Environmental Health Consultation Response

To	Mr S Davis
Date	17-08-2026
Planning Ref	F/36/26/OUT
Site Description	Paynters Croft Burndell Road Yapton Arundel West Sussex BN18 0HR
Date of Application	2026-07-08 00:00:00
Category	Outline Planning Permission
Recommendation	No Objection No Objection – with conditions Objection Holding Objection

NM03: Burndell Road - 30 Jun 2024

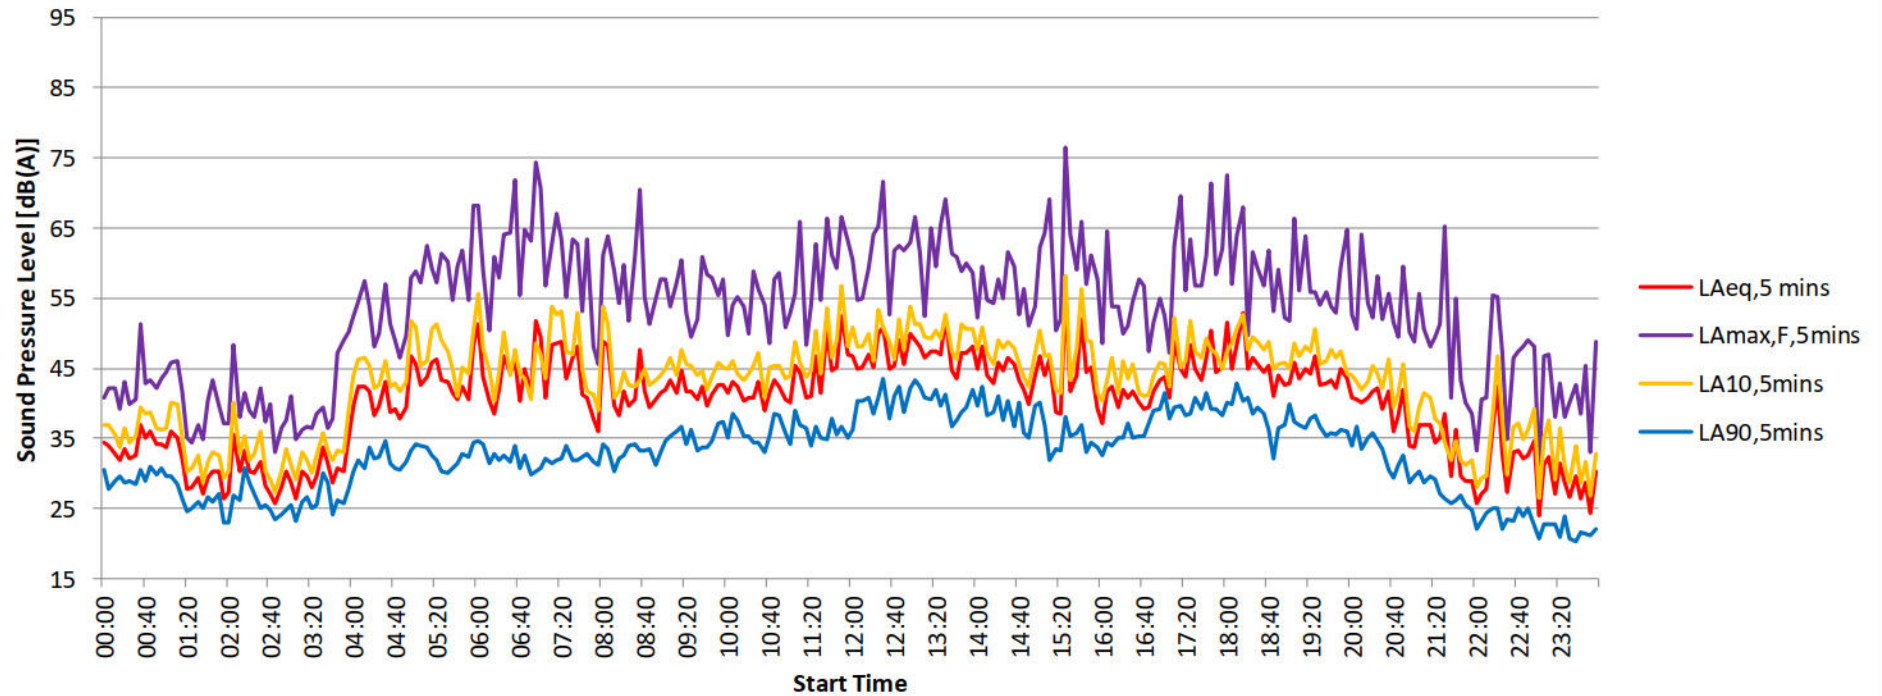
A noise assessment has been submitted, prepared by Phlorum, reference 13174, dated May 2026. The report is generally sound in approach; however, the noise survey work on which it relies was undertaken in 2024. Since that time, I understand that the adjoining industrial units have increased their hours of operation, this change may affect the noise climate to which future residents would be exposed.

On this basis, further confirmation is required to demonstrate that the noise levels and internal and external amenity standards set out in the Phlorum report remain representative and achievable having regard to the current and permitted operation of the adjoining industrial and waste uses.
